# CITY OF ALBUQUERQUE

March 26, 2019

**RE: Tierra Serena (Glendesto) Subdivision  
Lots 5, 6, & 13 - Accepted  
Revised Grading Plan Stamp Date: 1/23/18  
Certification Dated: 3/23/19  
Hydrology File: B18D020**

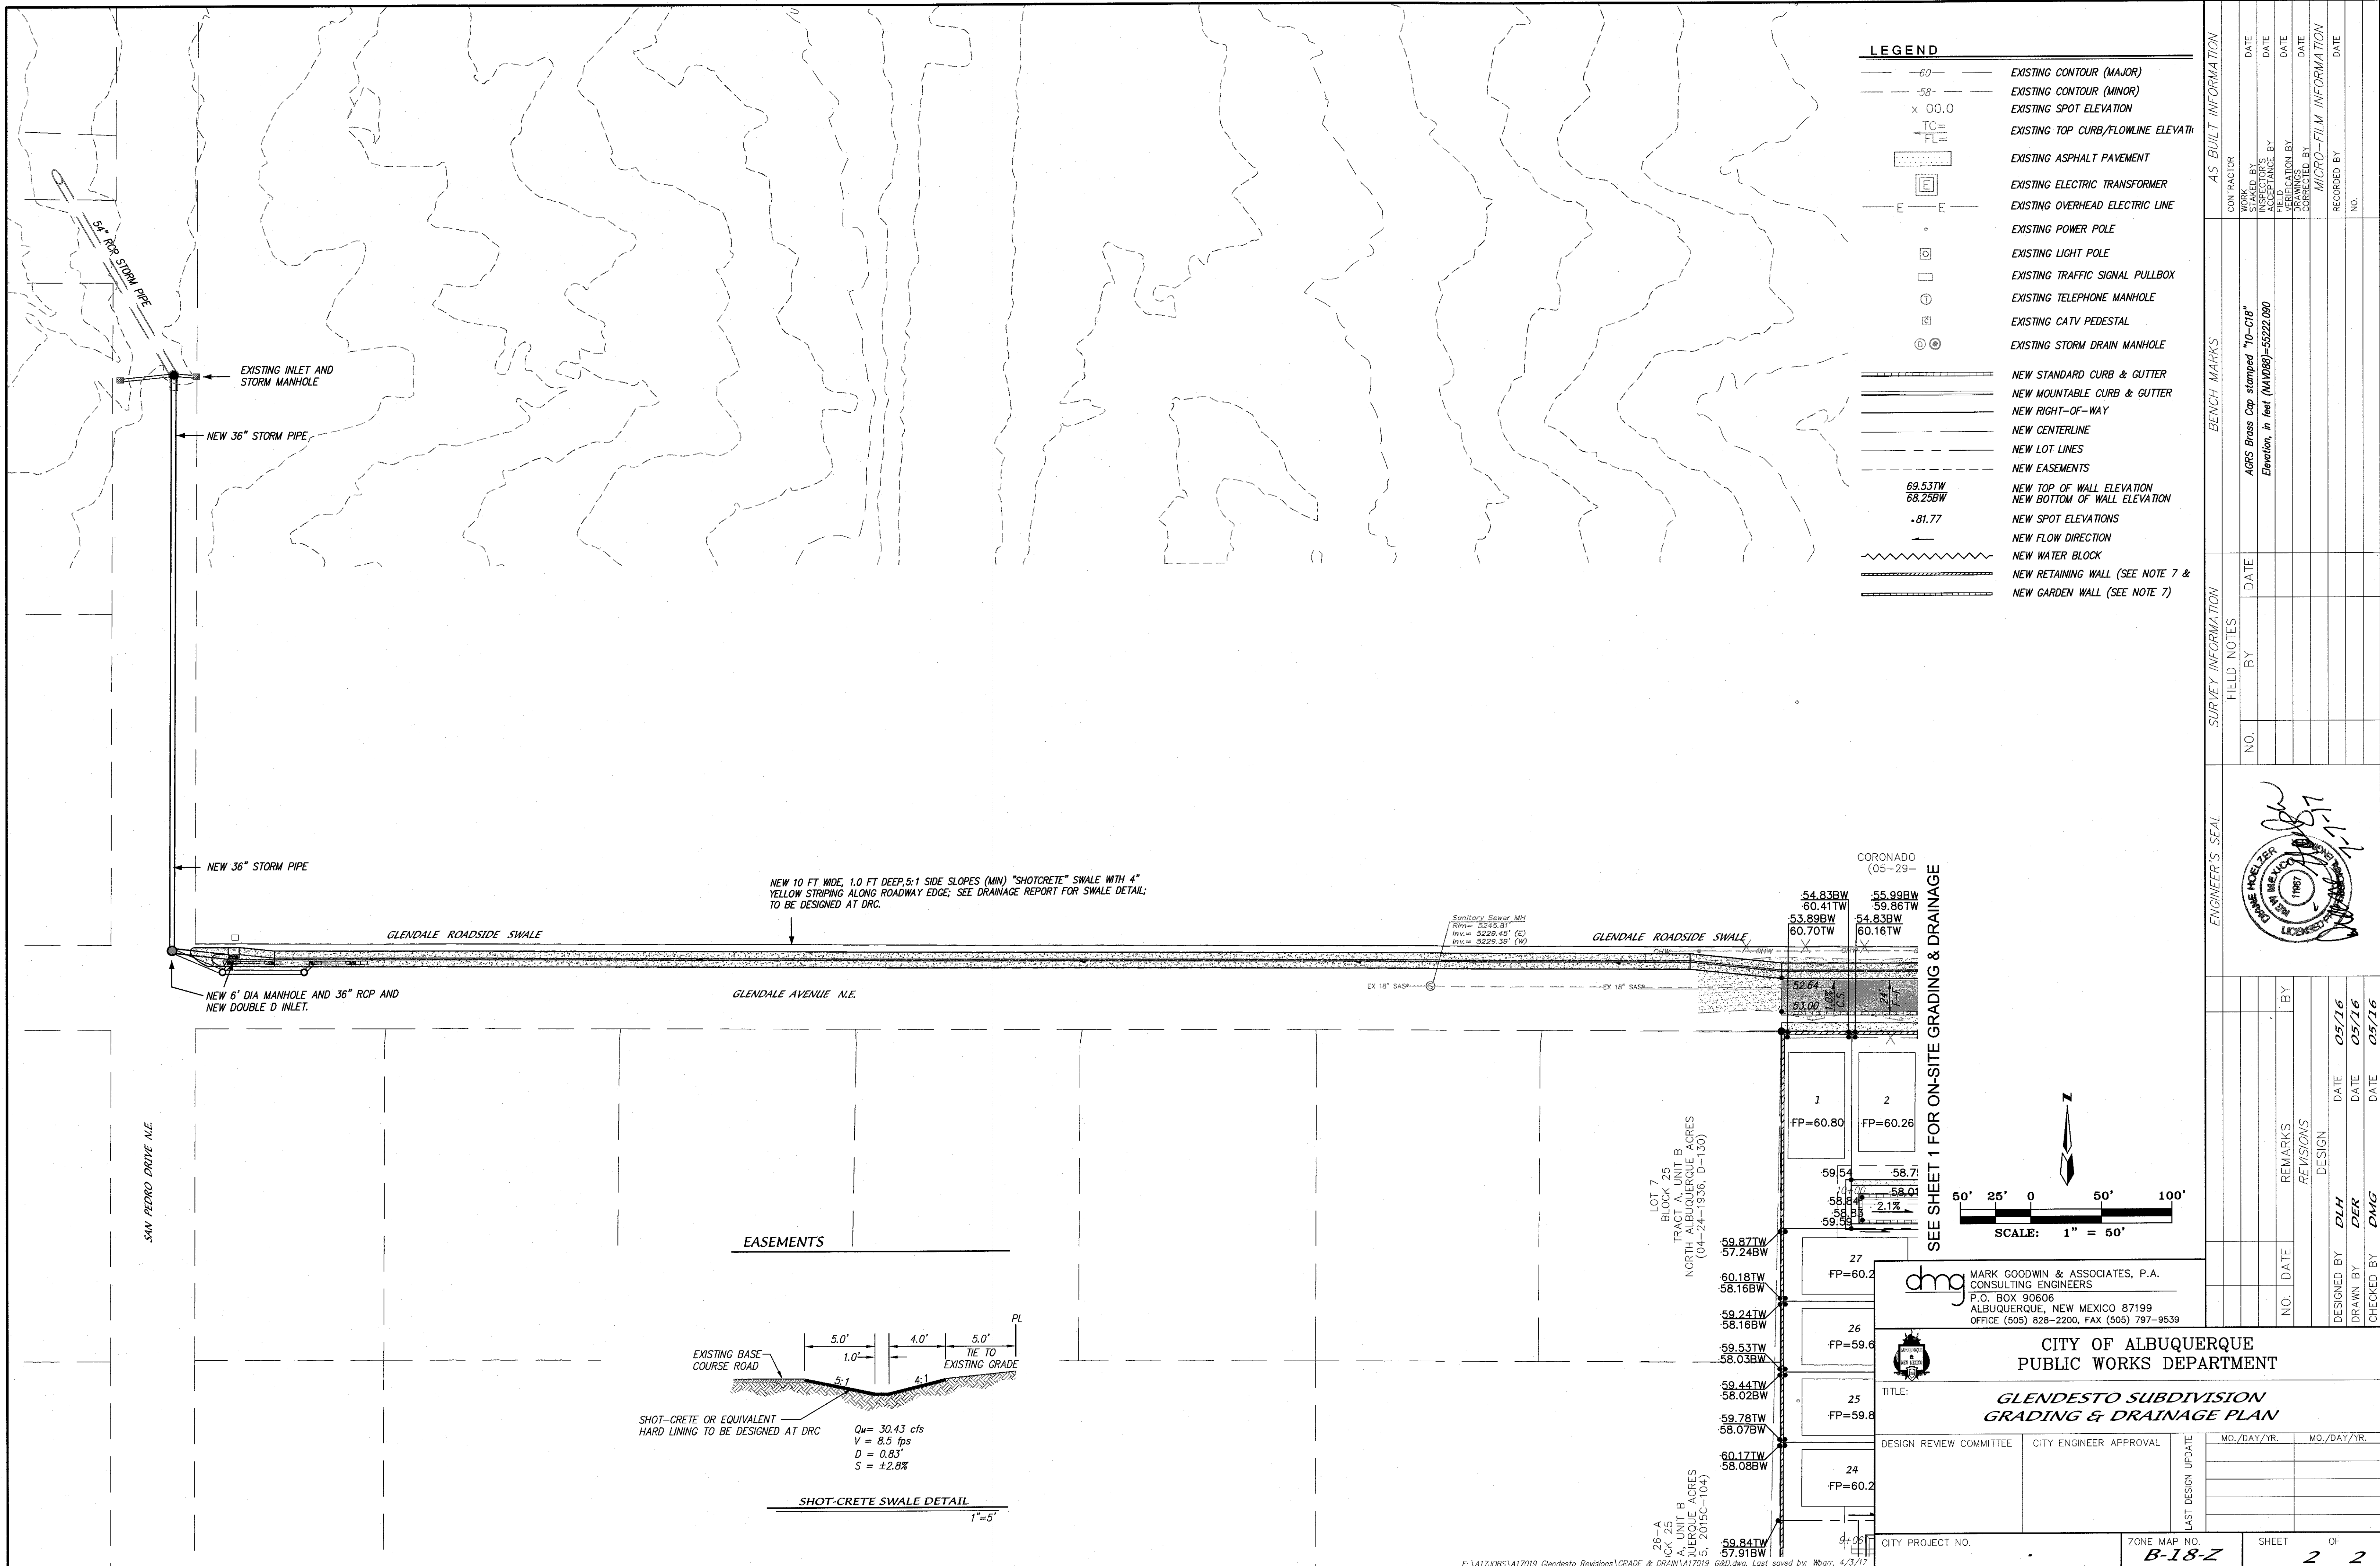
1. The Pad elevation is missing for Lot 14 and the parking lot needs to be removed prior to certifying Lot 14.
